Your Ref: 000014304
Our Ref: FG/156/12/ 20-11-2012
Please ask for:
Melissa Osland

Alterations
28 Ferring Street Ferring

DRW NO 6b SCALE 1/50 (A3)
PROPOSED FRONT ELEVATION

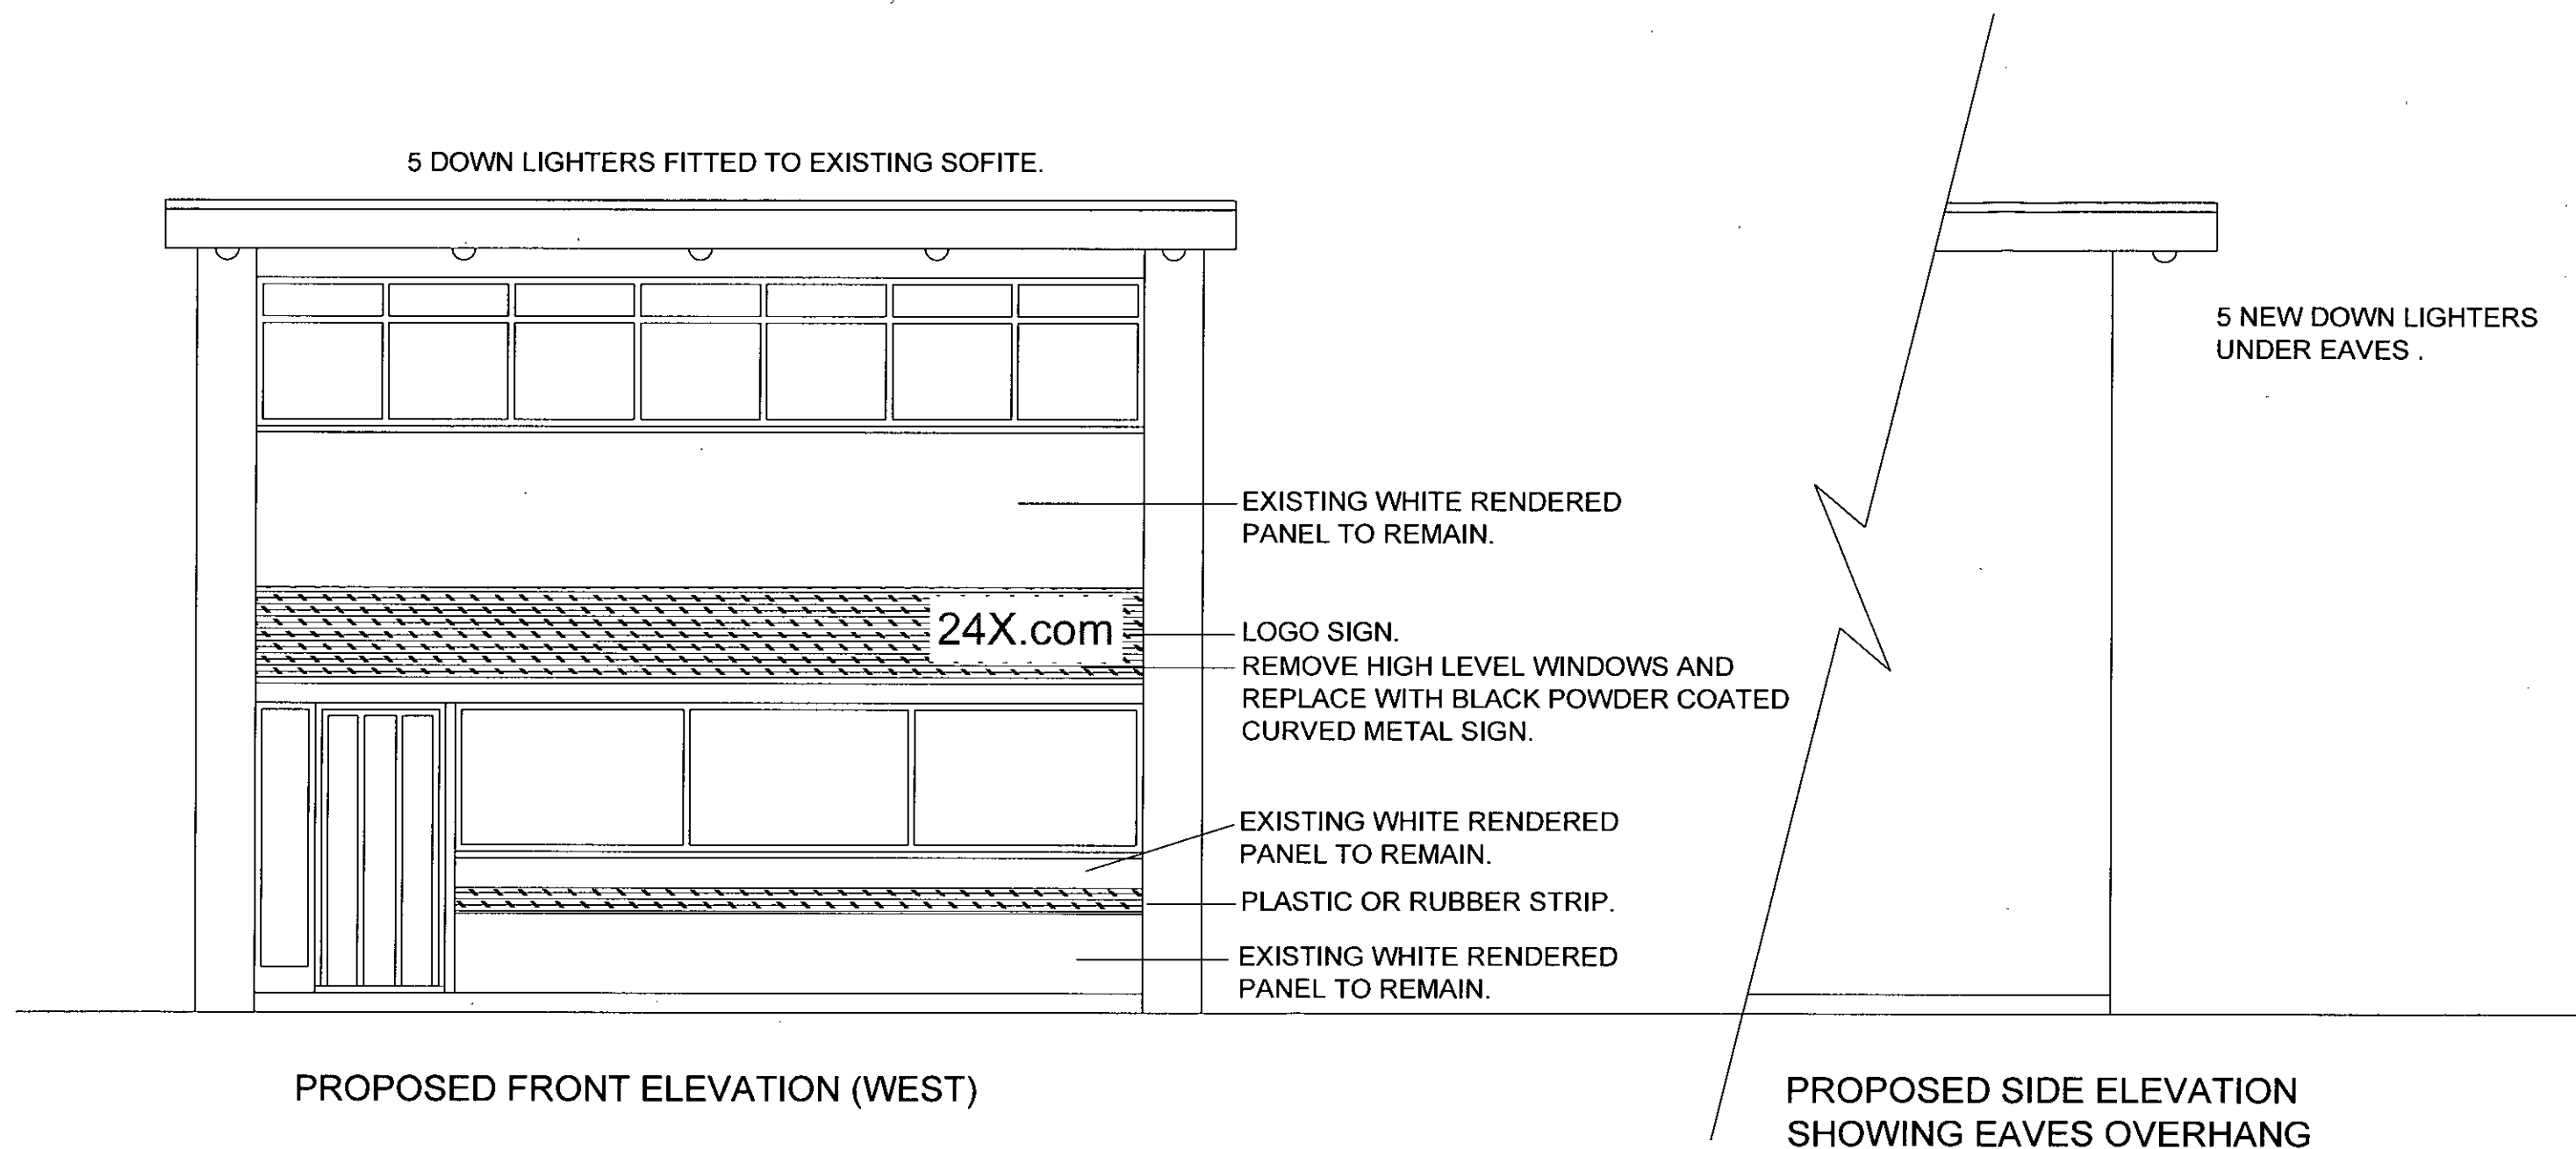
The proposed material for the facia, brushed stainless steel, is totally out of keeping with the surrounding conservation area and we ask that the application be refused.
